# Charlotte Department of Transportation

## Memorandum

**Subject:** Rezoning Petition 08-083: Located on the northeast corner of the Plaza and Barrington Drive. (revised 5/12/08)

EXISTING SITE PLAN

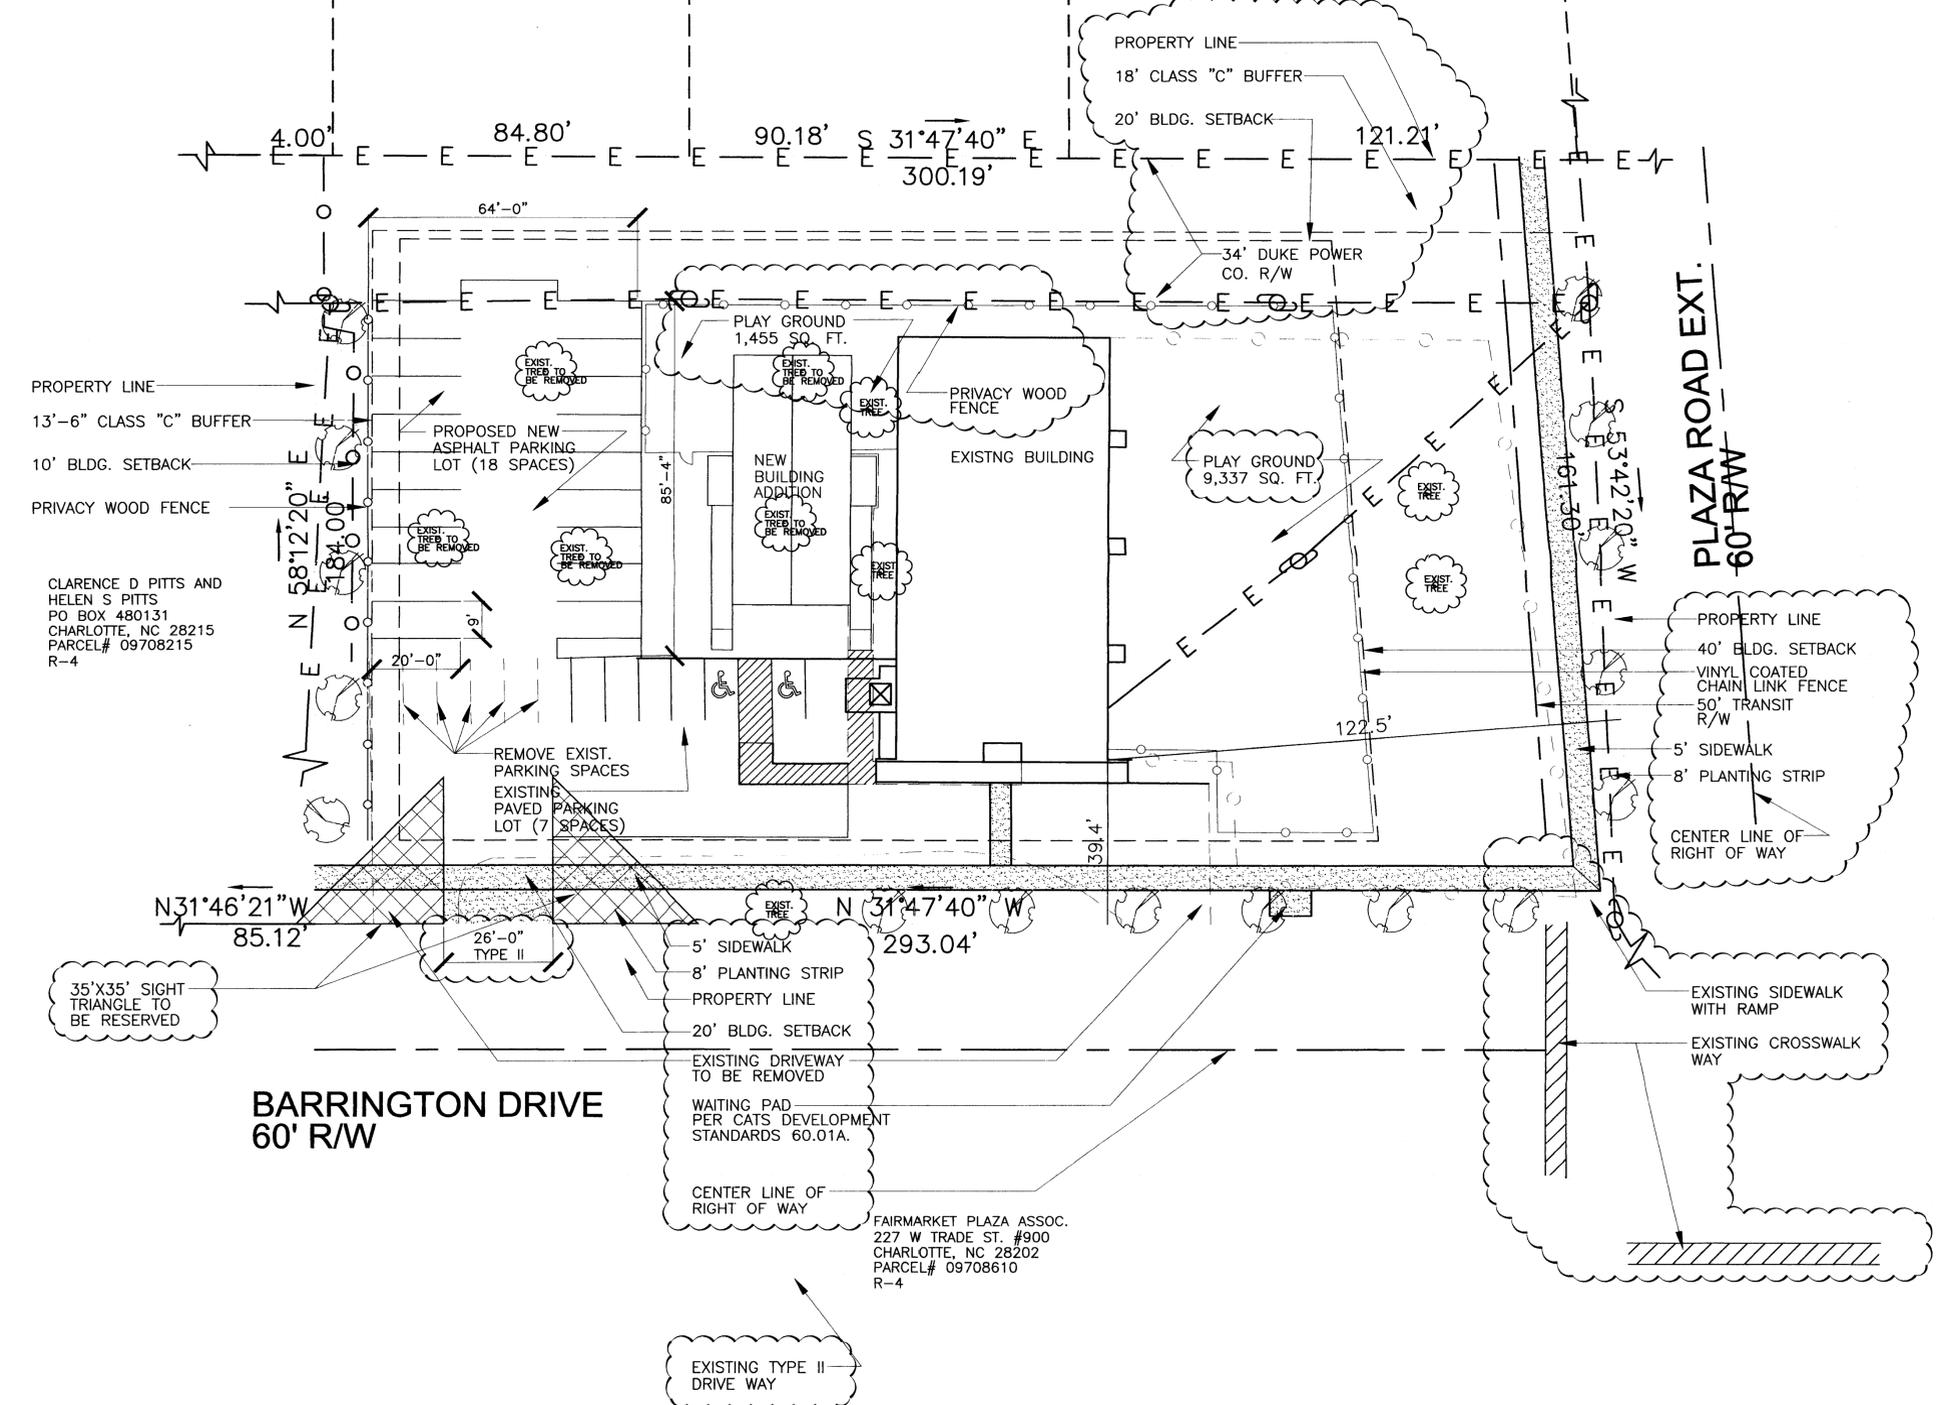
1. The developer must provide 8-foot planting strips and 6-foot sidewalks along both The Plaza and Barrington Drive. (*Previous comment*)
2. The existing driveways are in disrepair and need to be replaced during construction. As part of this work the driveway closest to the northern property line needs to be moved to a location in alignment with the new parking lot aisle. The driveway needs to be Type II Modified and 26 feet in width. (*Previous comment*)

3. The Plaza is a major thoroughfare requiring a minimum of 100 feet of right-of-way. The developer/petitioner should convey right-of-way in fee simple title to meet this requirement, measuring 50 feet from the centerline of the roadway. (*Previous comment*)
